**Application Reference:** 6/2023/1354/COND

**Proposed development at:** 71 Station Road Cuffley EN6 4HG

**Proposal:** Submission of details pursuant to conditions 1 (Contamination), 2 (Footway crossovers and dropped kerbs), 3 (Construction Management Plan), 4 (Drainage), 5 (Materials), 6 (Fence height), 7 (Noise Impact), 8a (Accessible and adaptable housing), 9 (Biodiversity), 10 (Energy and sustainability), 11 (Cycle provision, refuse and recycling), 16 (External lighting), 17 (Bollards for car parking) and 20 (Parking allocation) on planning permission 6/2021/0456/MAJ

SCALE @ A1: 1:100	DESIGN-DRAWN: MC	DATE: 20/07/2022
PROJECT NO: 3906	DRAWING NO: C4000-S278-3906

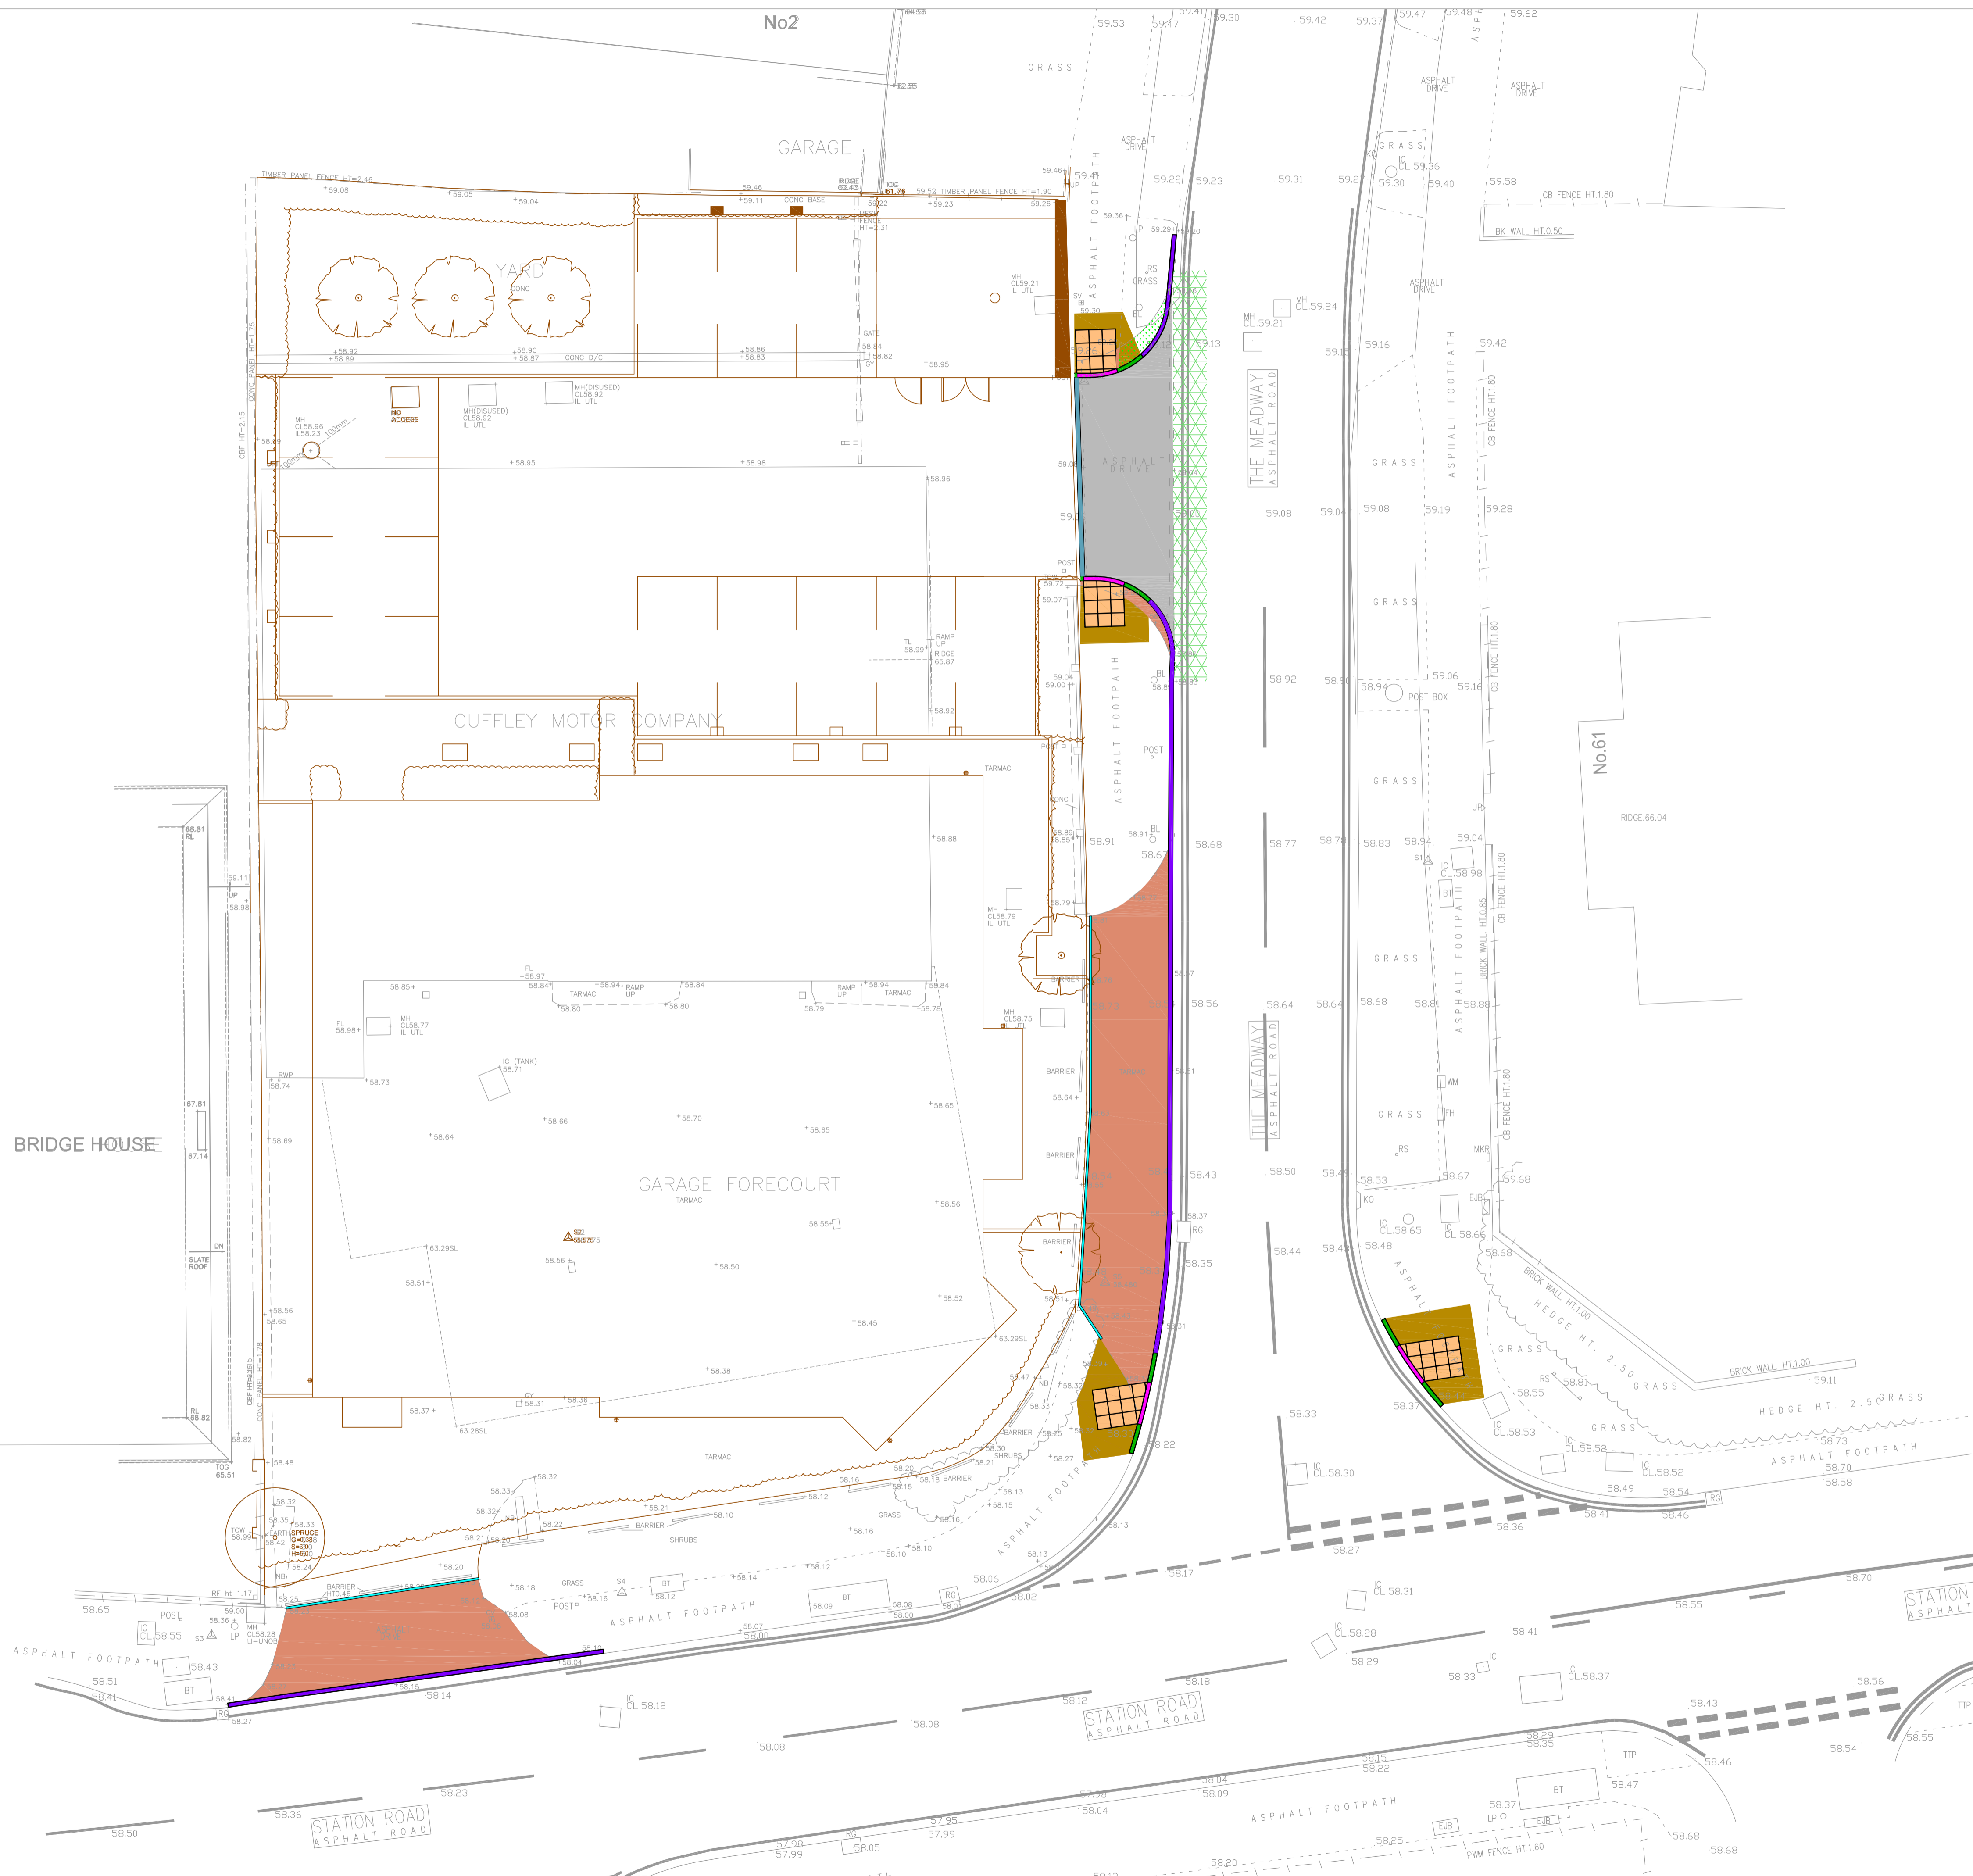
- General Arrangement (drawing number: C1000-S278-3906)
- Setting Out Arrangement (drawing number: C2000-S278-3906)
- Site Clearance (drawing number: C3000-S278-3906)
- Proposed Pavement and Kerbing Layout (drawing number: C4000-S278-3906)
- Standard Details (drawing number: C5000-S278-3906)
- Existing Utilities (drawing number: C6000-S278-3906)
- Proposed Road Marking Layout (drawing number: C7000-S278-3906)

As development has commenced, this condition cannot be discharged. The details submitted would have been sufficient to discharge the details reserved by this condition.

salvatore zaffuto	architecture	date	11.06.2020	title	Proposed 12No Flats Proposed Site Plan & Location Plan
		scale	1:100/1:250 @ A1		
		drawn	SZ	client	drawing no. D 446.002C
		client	M K Pinner 26 Worcester Crescent London, NW7 4LR

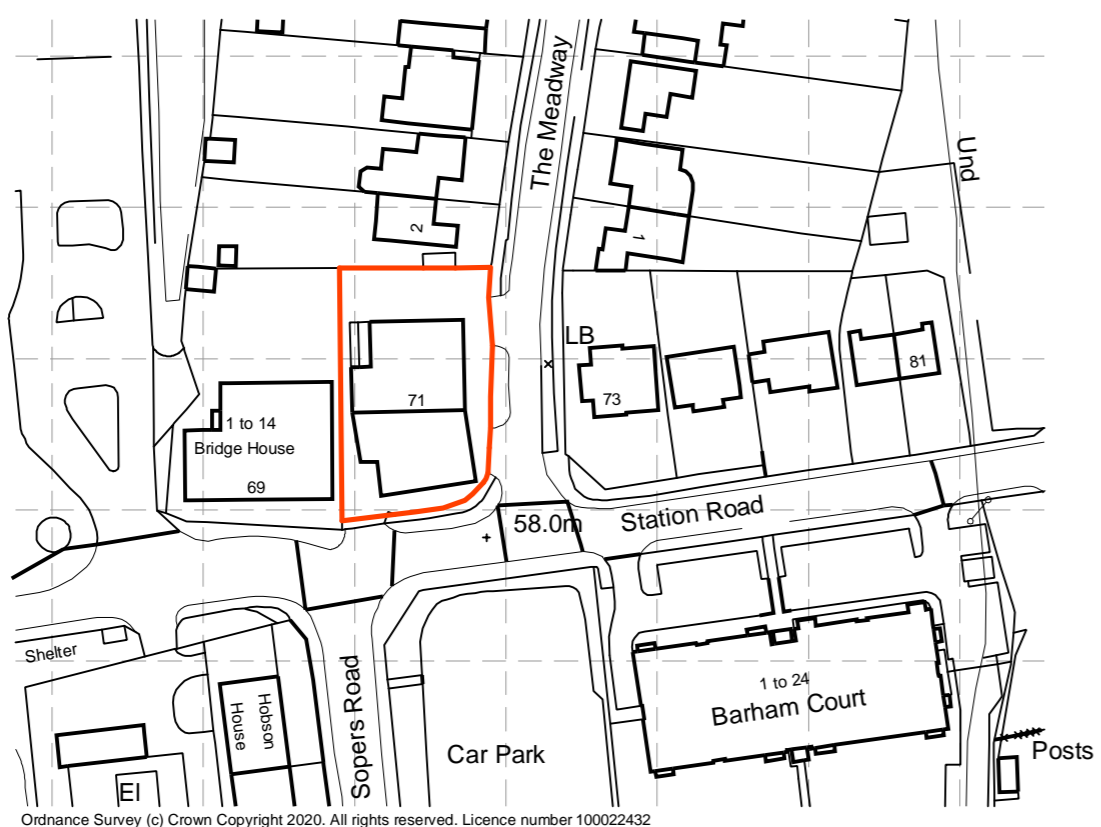
The submitted Proposed Site Plan and Location Plan (drawing number: D 446 002C) illustrates and annotates the bollards and is sufficient to discharge the details reserved by this condition. Please note that to fully comply with the requirements of this condition, the approved details must be implemented prior to first occupation of the development and retained permanently thereafter.

The submitted Proposed Site Plan and Location Plan (drawing number: D 446 002C) shows that each flat would have a single parking space. This is acceptable and discharged the details reserved by this condition. Please note that to fully comply with the requirements of this condition, the car parking allocation must be provided in accordance with approved details and retained thereafter.

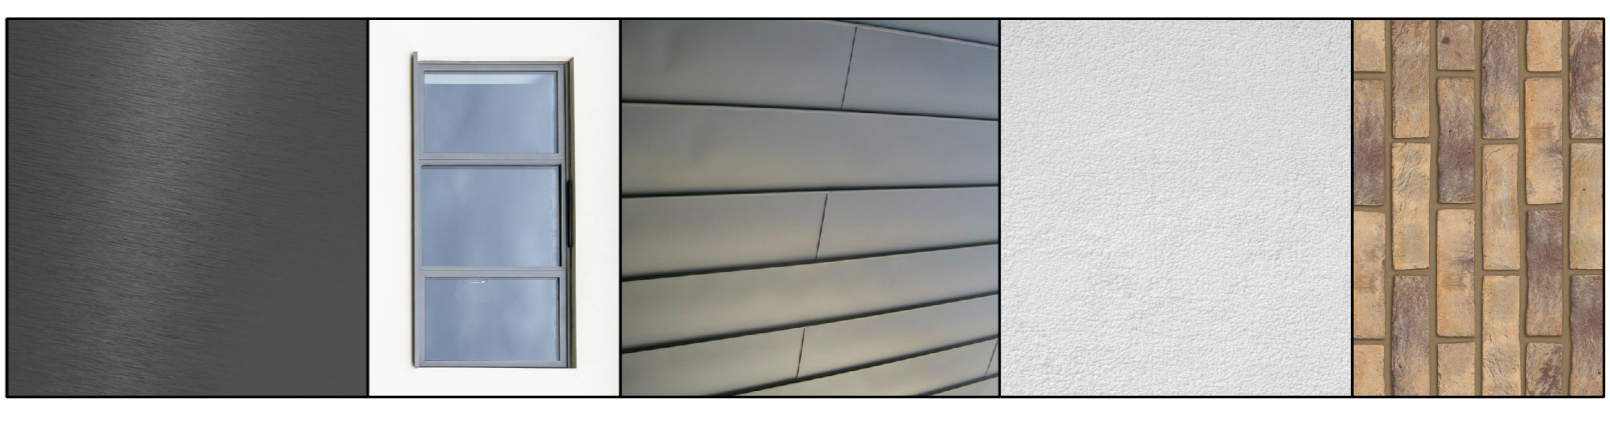
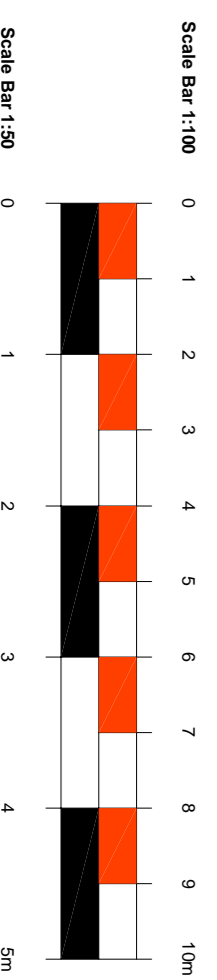
- Proposed GF/FF Plans & South/East Elevations (drawing number: D 446 003C)

No details of the external surfaces of the flat roof for the flatted block and the secure cycle and refuse & recycling store have been submitted. The details submitted are therefore insufficient and refused.

The submitted Proposed GF/FF Plans & South/East Elevations (drawing number: D 446 003C) includes details of the number, layout and location of all units that will comply with Part M4(2) of the Building Regulations 2010. The details are acceptable and discharges Part A of this condition.
